### SSD 6603 – Site 68, Sydney Olympic Park – Modification 1: Further information request

We write on behalf of *Ecove Group Pty Ltd* (The Proponent) to provide a formal response to your request for further information regarding SSD 6603 Modification 1, dated 2 November 2015.

#### FURTHER INFORMATION REQUEST (CAR AND BICYCLE PARKING PROVISION AND AMENDMENTS TO CONDITIONS)

Plan
Basement Level B1

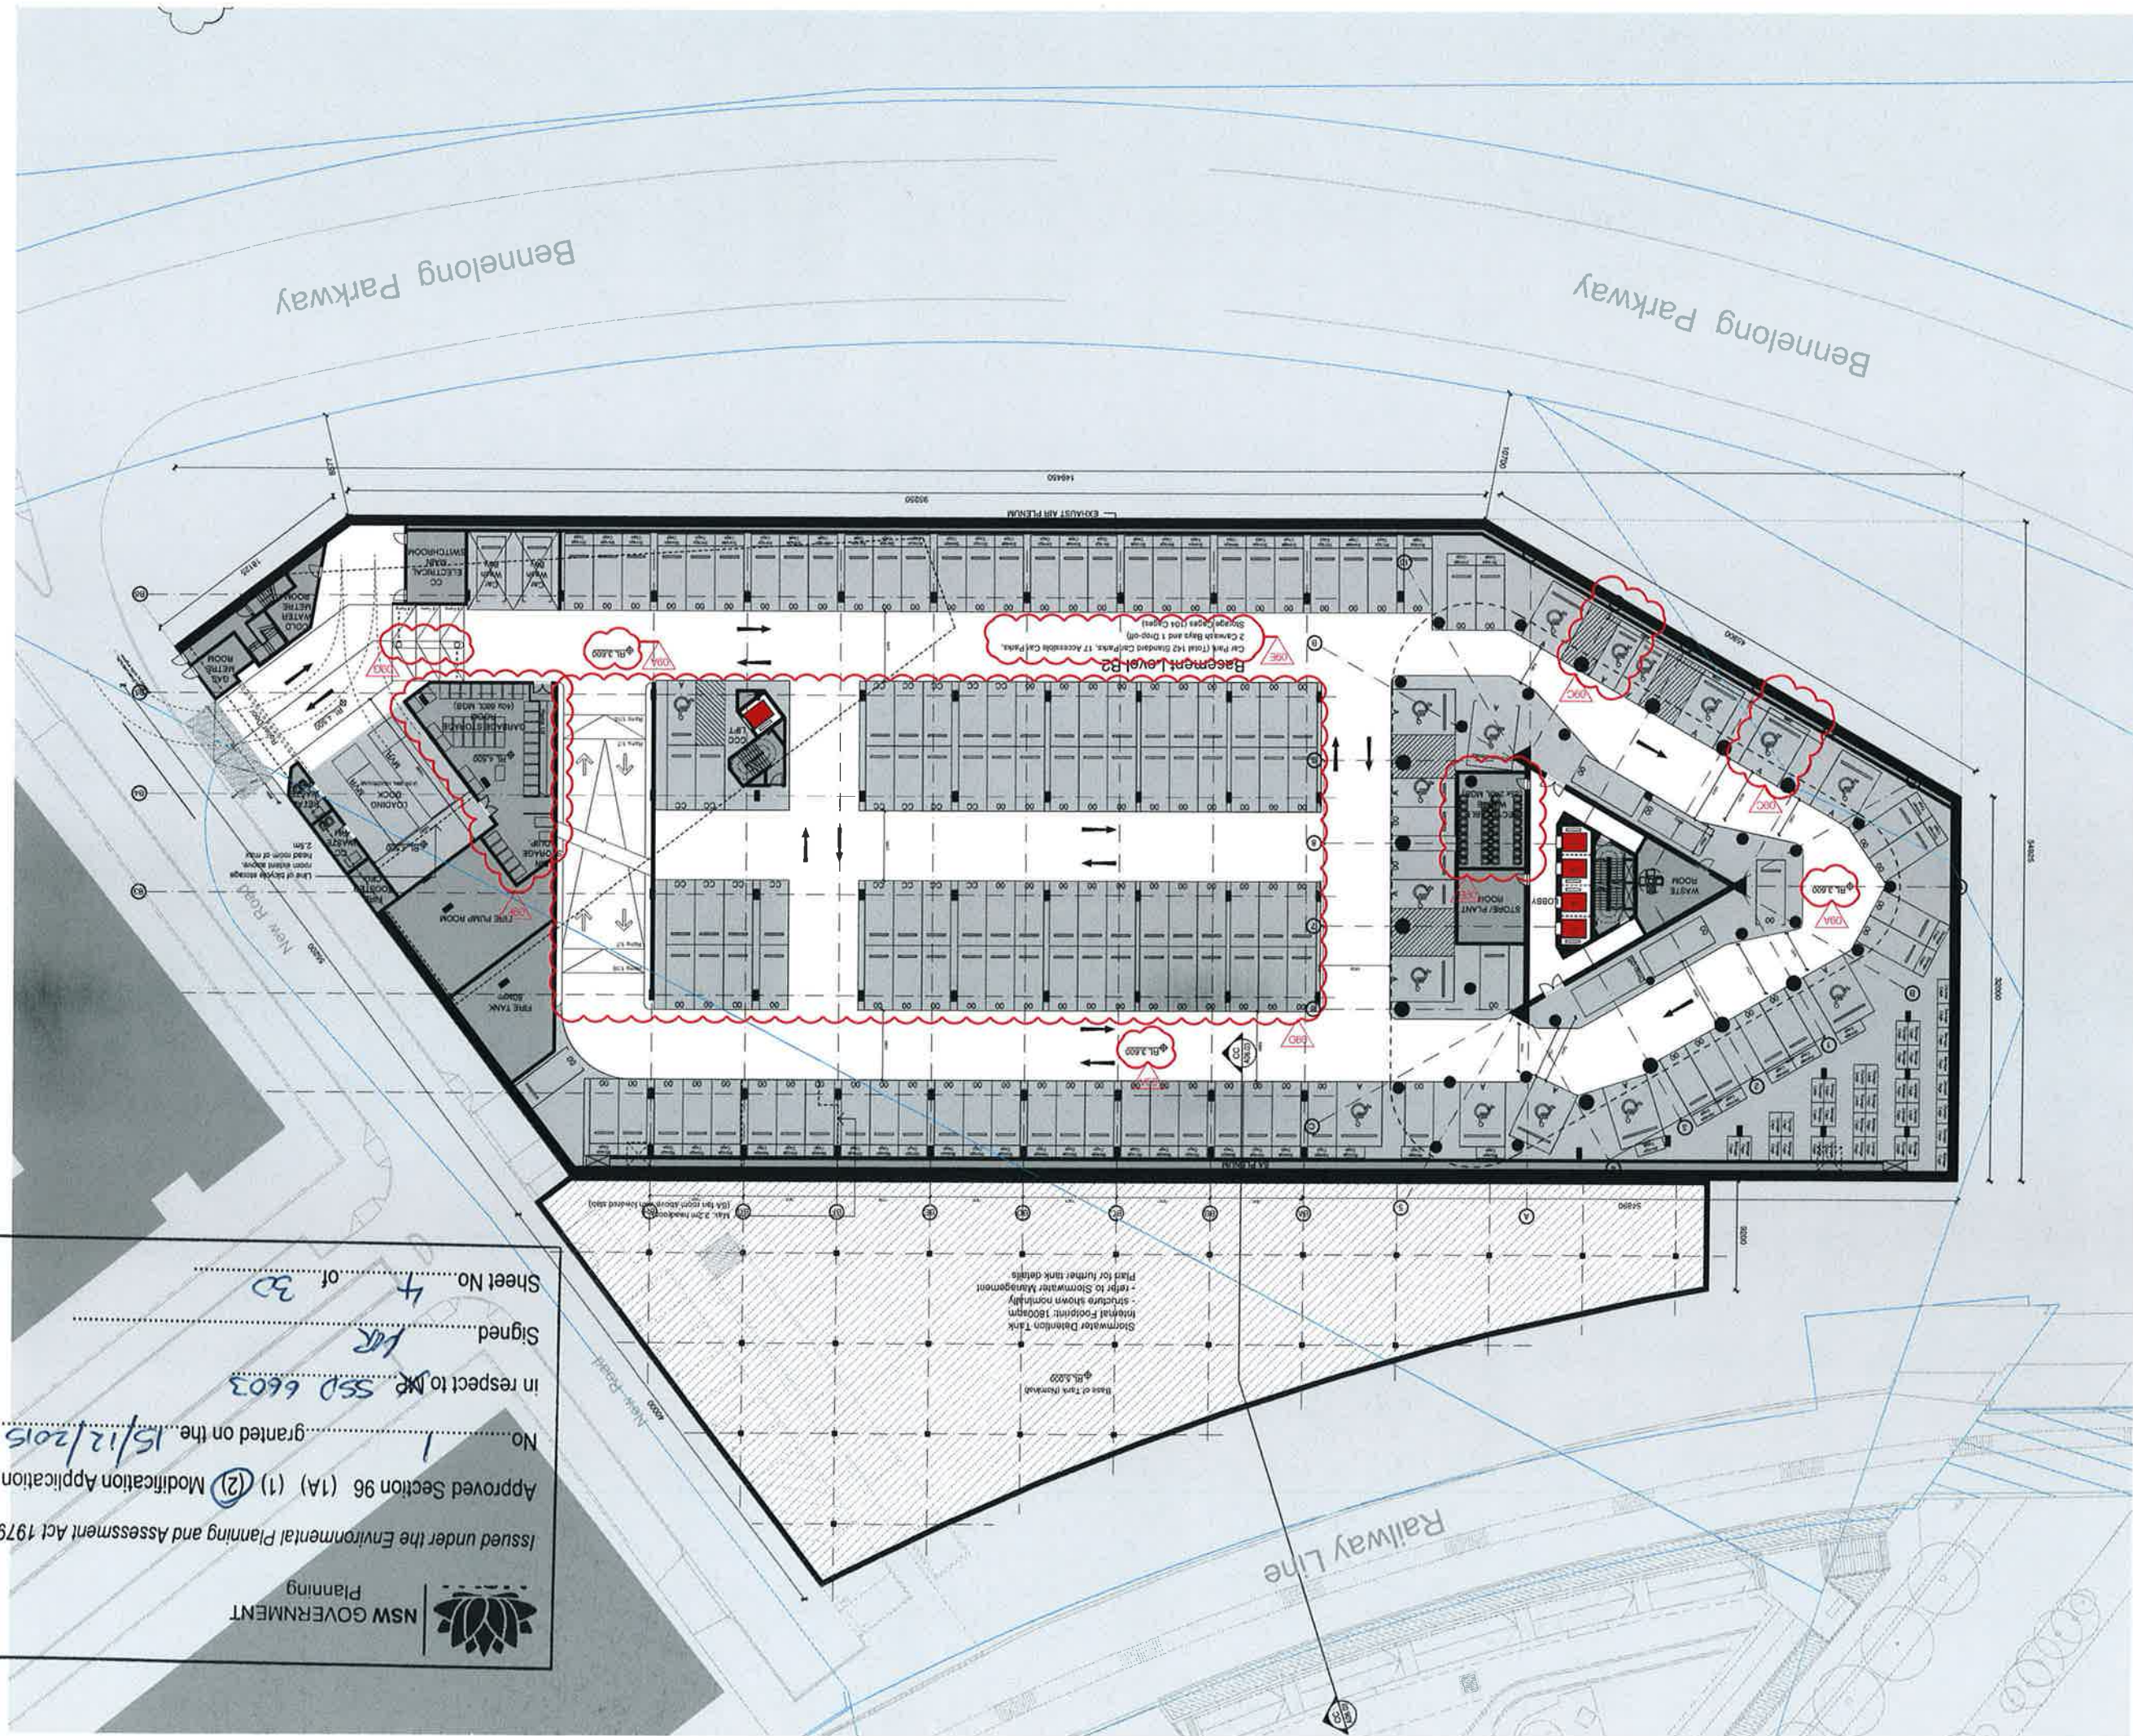
3. *With regard to the amended bicycle parking provision can you confirm:*

- *The breakdown between residential and non-residential bicycle parking provision. If there has been a reduction in non-residential cycle parking please provide reasons/justification for this;*
- *Whether non-residential, visitor and residential spaces are proposed to be co-mingled at basement level B1. If this is the case please confirm how access will be provided and how the store will be managed/kept secure;*
- *Whether a CPTED assessment of the basement level B1 bicycle store has been undertaken. I notice that the store only has two points of entry/escape – please provide comments on the potential for entrapment and what security measures will be employed to ensure the safety of future cyclists.*

The current proposal co-locates residential and visitor bicycle parking spaces within the bicycle store on basement level B1. Bates Smart has since reviewed this proposal and agrees there are potential security and safety issues associated with the management of such a space, which may not necessarily be mitigated through the use of a security camera or monitoring system.

Accordingly, it is proposed to relocate the 98 visitor bicycle parking spaces from within the bicycle store on basement level B1 and distribute throughout the public domain in the form of an additional 49 simple stainless steel bicycle racks. The racks are proposed to be strategically placed at points of interest throughout the public domain, improving visibility and usability of the public facilities, and removing the potential security and safety issues identified.

To facilitate the above proposal, it is requested that a condition of consent be incorporated into the modified development consent, requiring the relocation of visitor bicycle parking spaces from within basement level B1 to the public domain (refer modified condition A12 in the following section).

A total of 558 bicycle parking spaces are to be provided, including 98 on racks within the plaza level and/or public domain, 199 on racks within the Basement (with level street access), and 261 within storage cages in the Basement.
